June 11, 2019

Addendum No. 1

RE: Contract # C204428
WBS # 38400.3.3
F. A. # BRZ-1433(9)
Franklin County (B-4516)
BRIDGE #52 OVER SANDY CREEK ON SR-1433.

PROJECT NO. B-4516
FRANKLIN COUNTY
 STATION: 15+17.00 -L-
 SHEET 5 OF 6

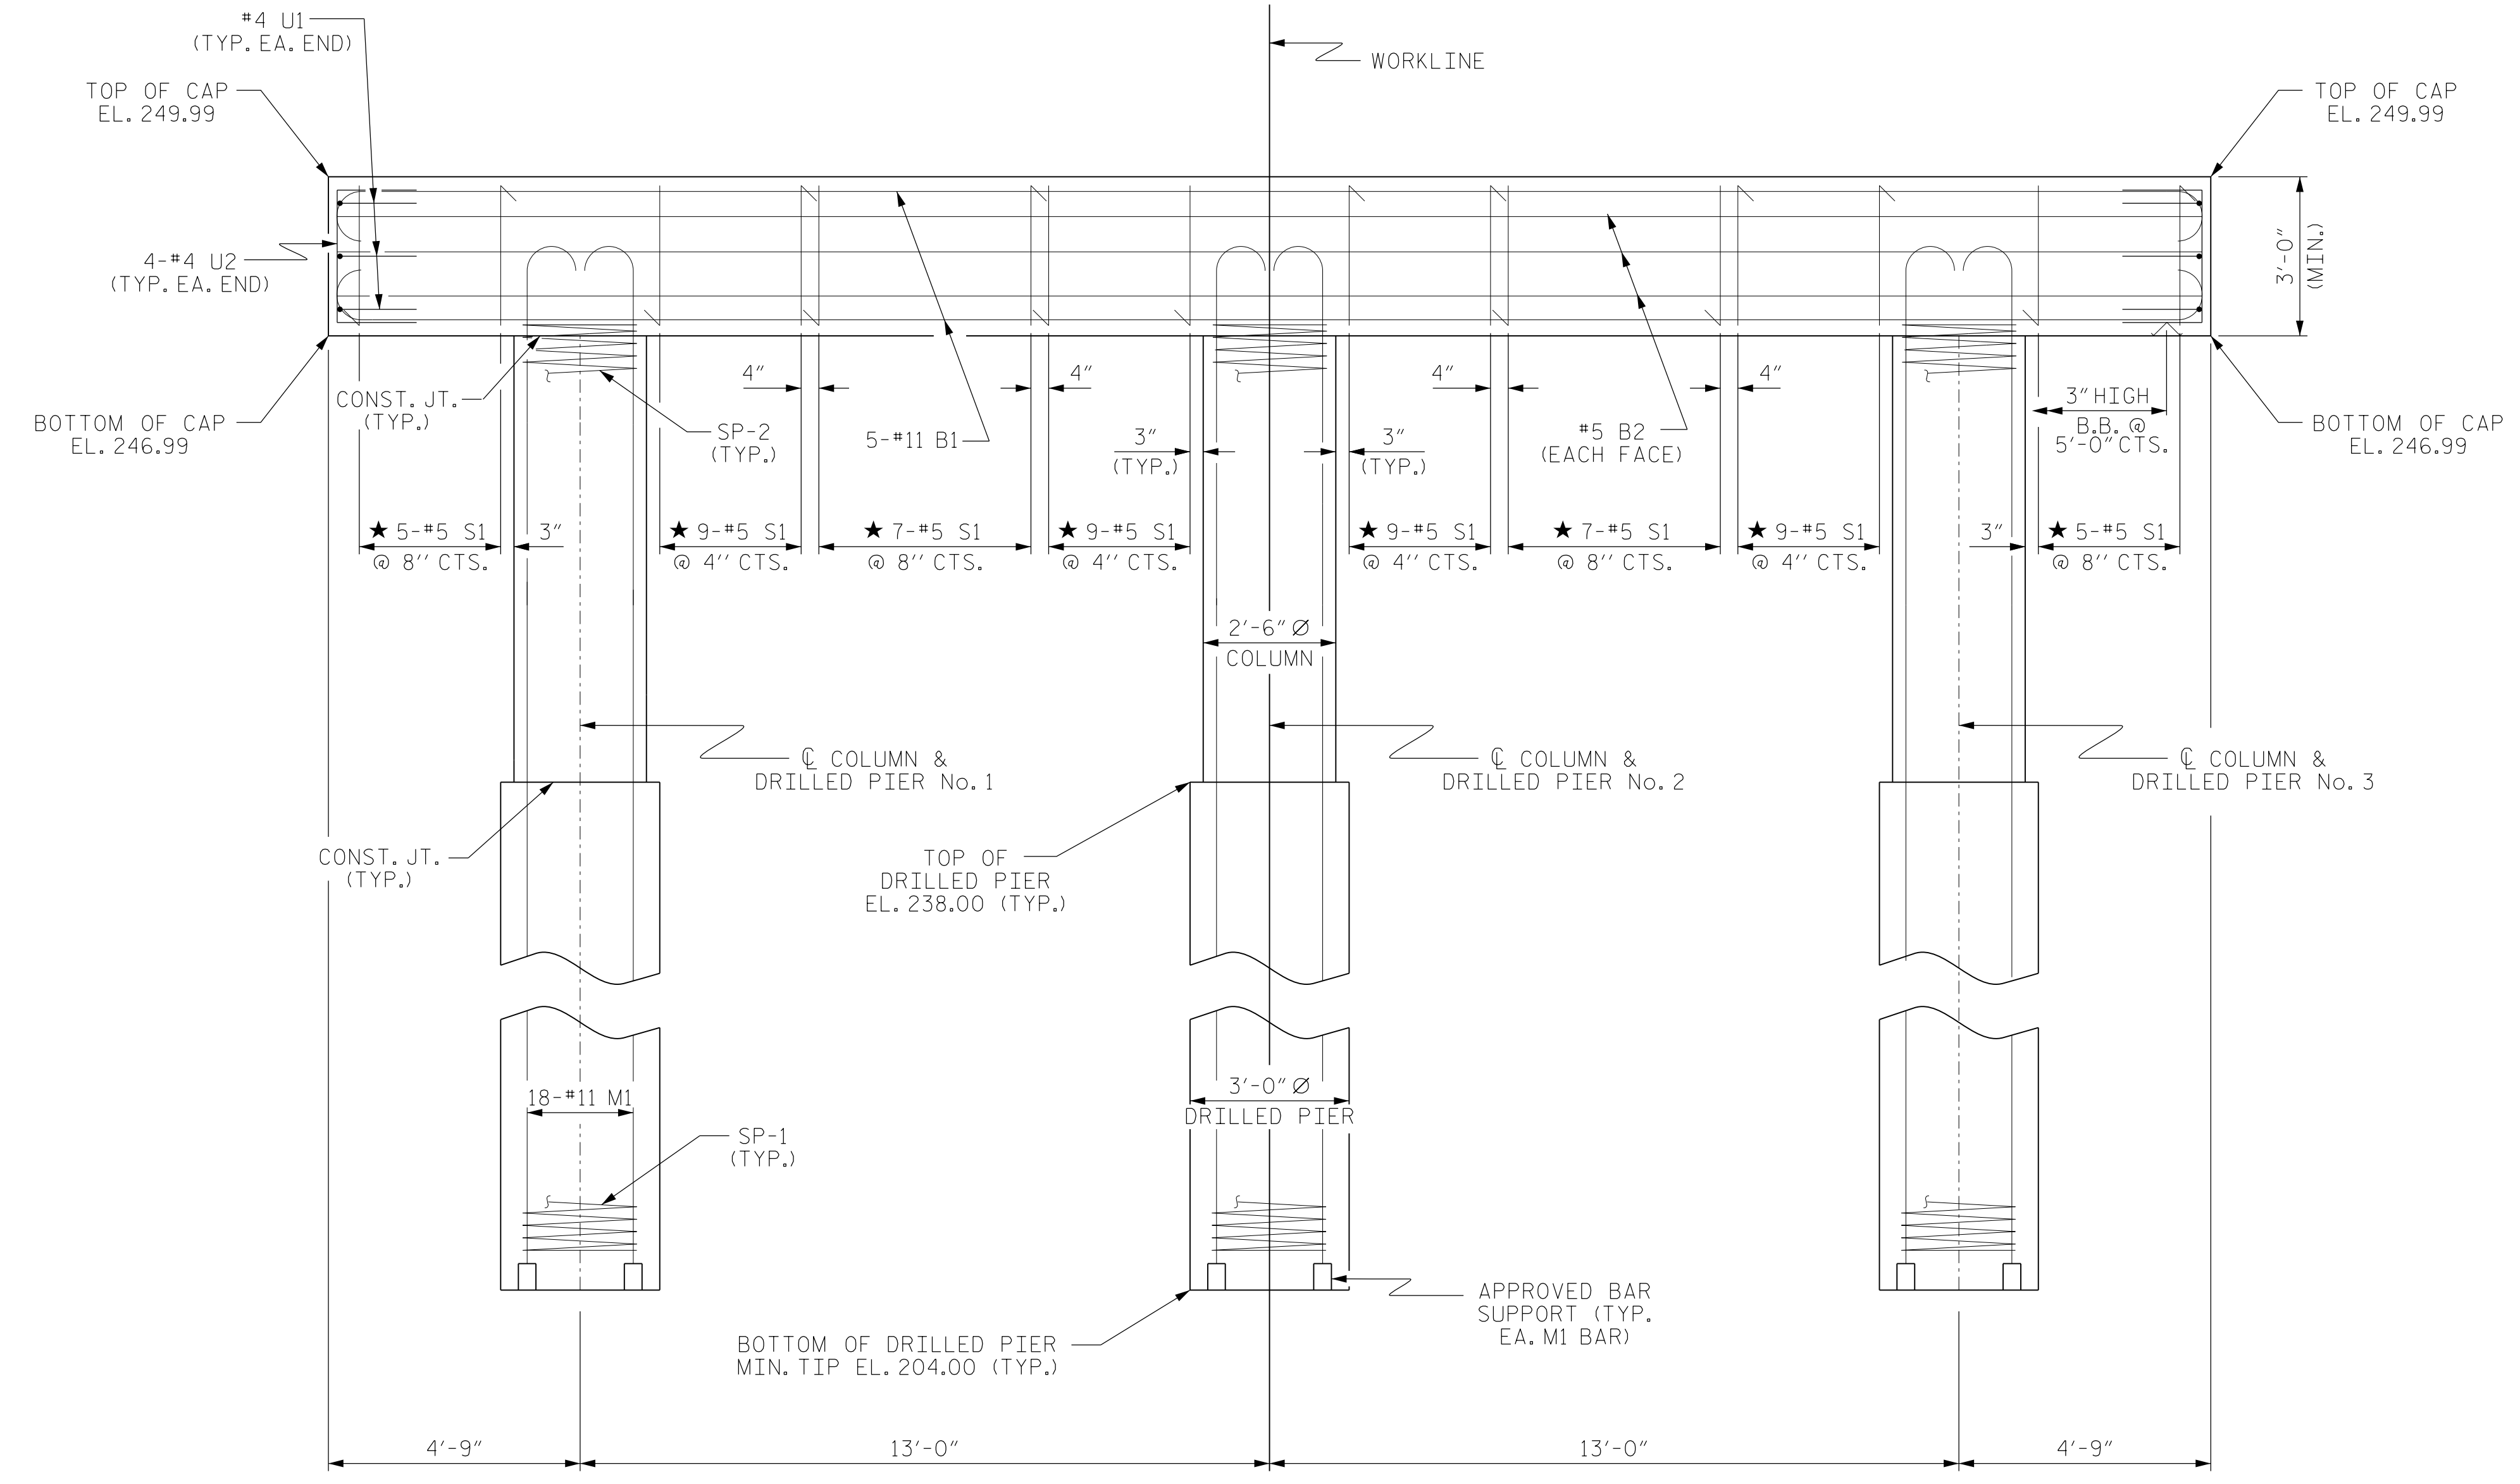
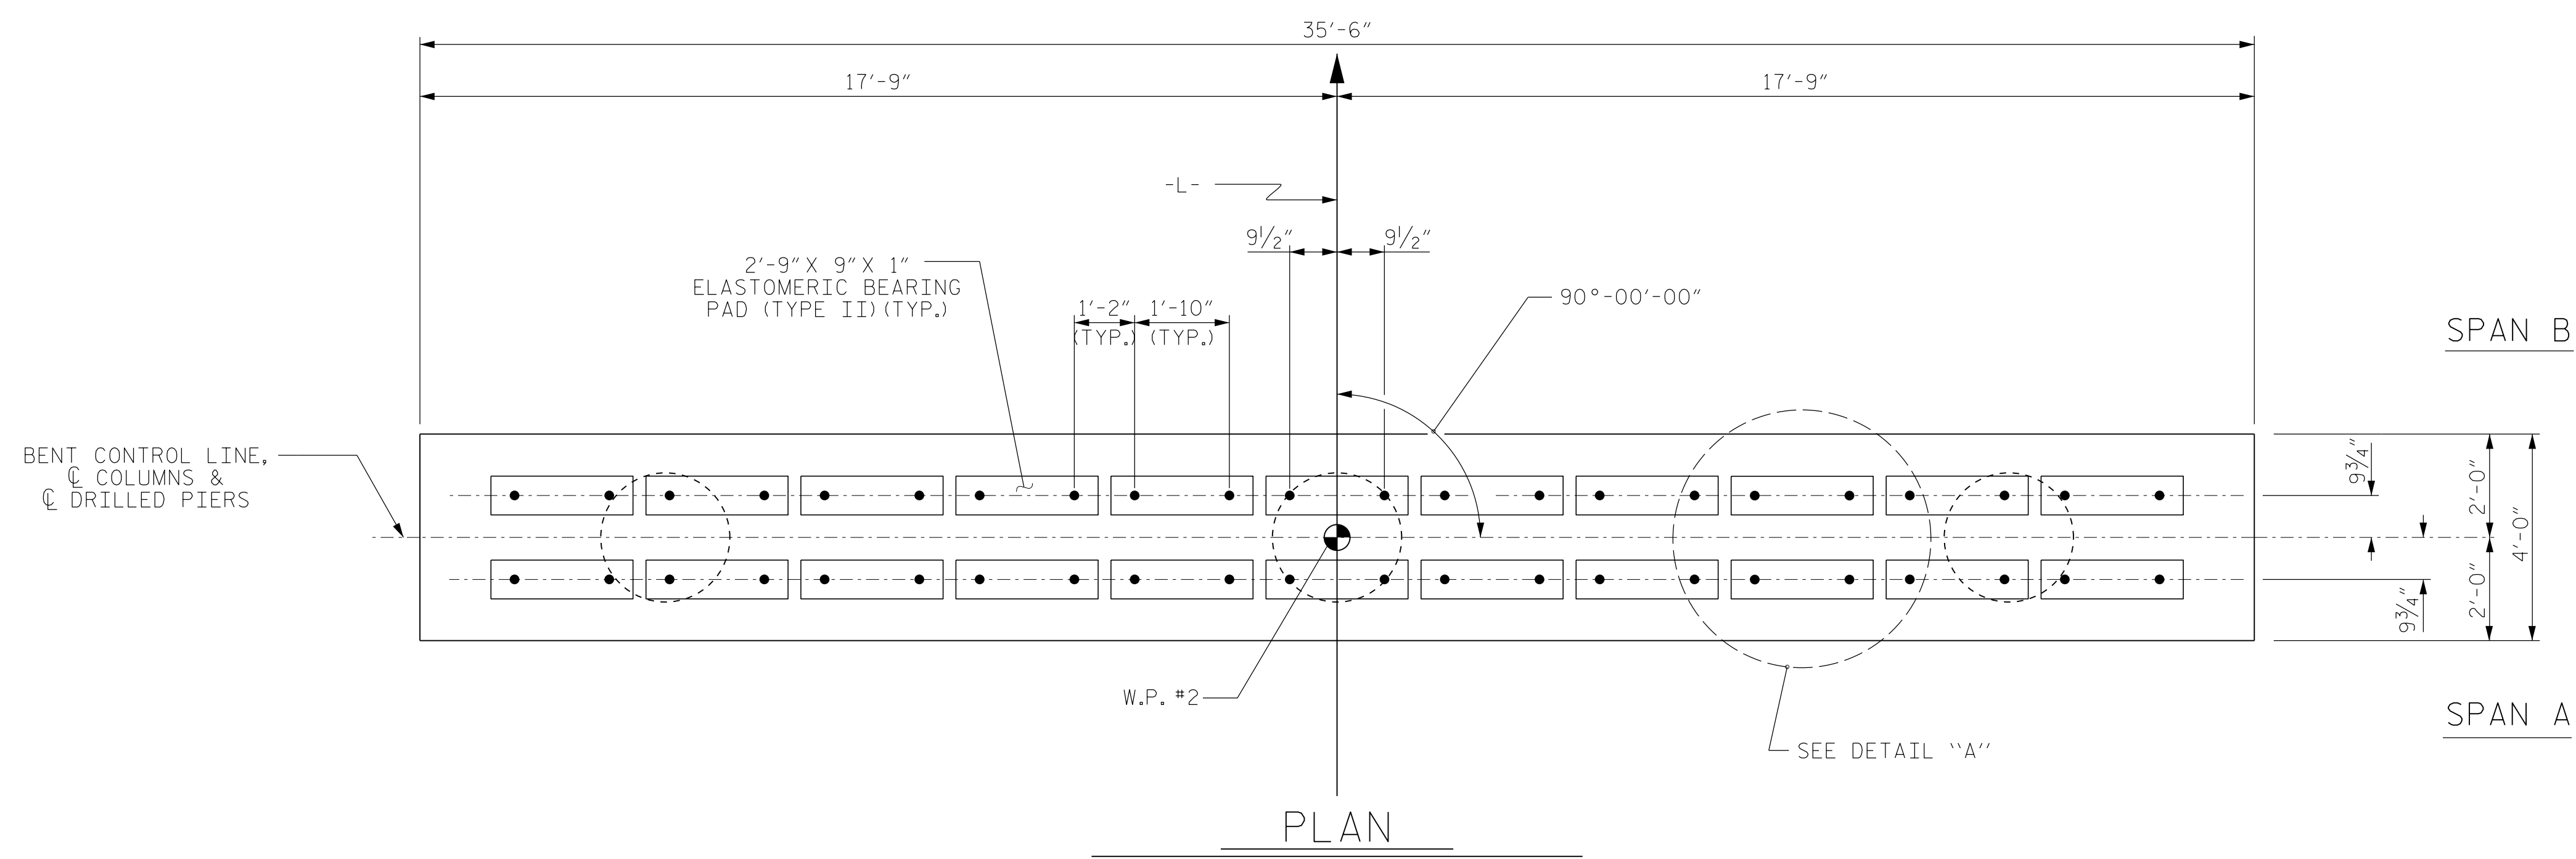
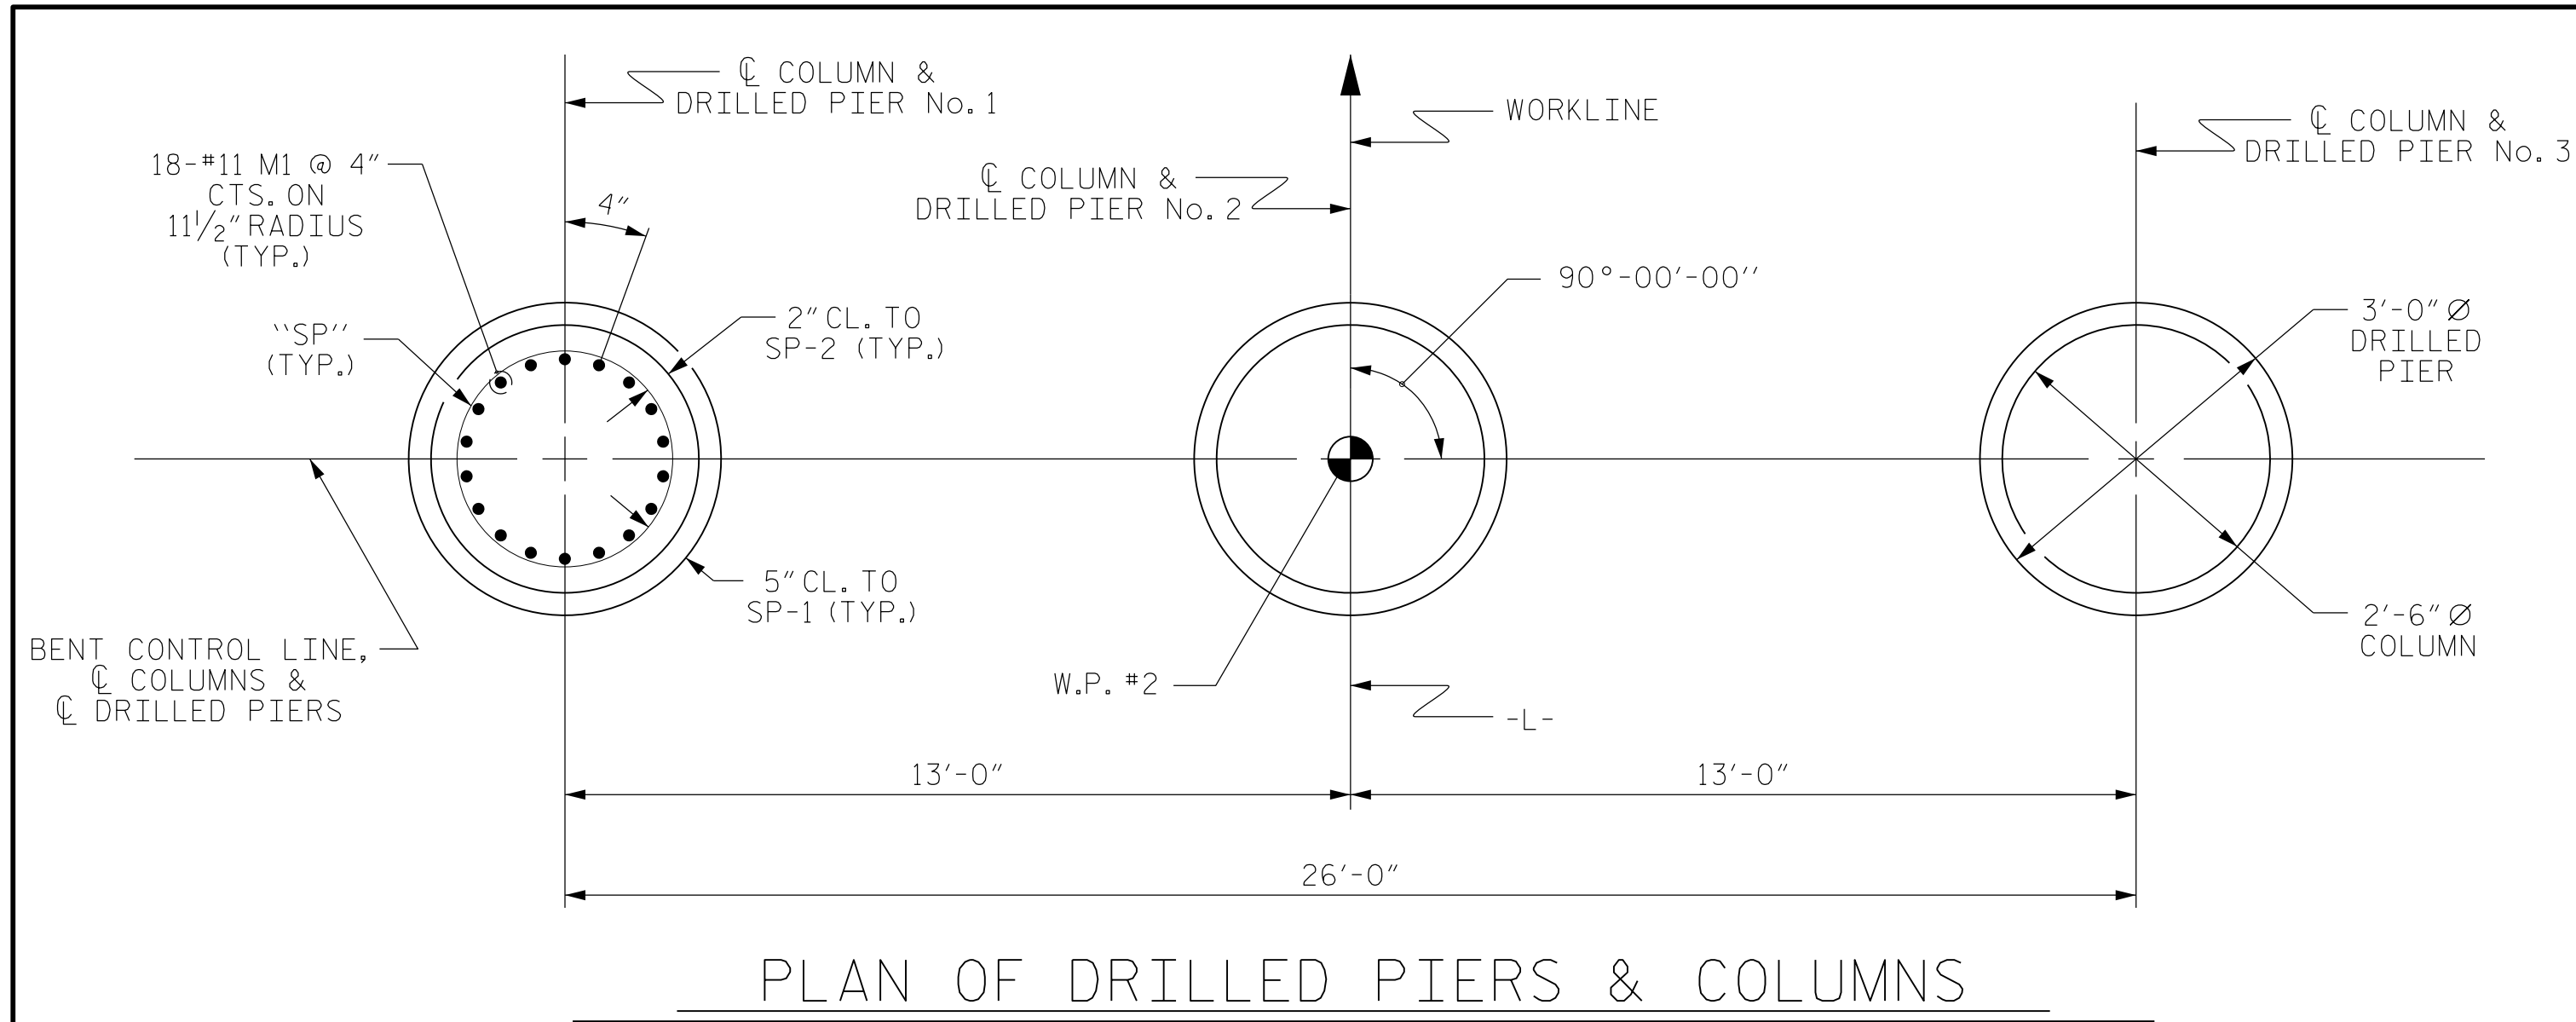
<u>Item</u>	<u>Description</u>	<u>Old Quantity</u>	<u>New Quantity</u>
0069-8105520000-E-411	3'-0" Dia. Drilled Piers in Soil	12 LF	90 LF
0070-8105620000-E-411	3'-0" Dia. Drilled Piers Not in Soil	90 LF	12 LF

The Contractor's bid must include these pay item revisions.
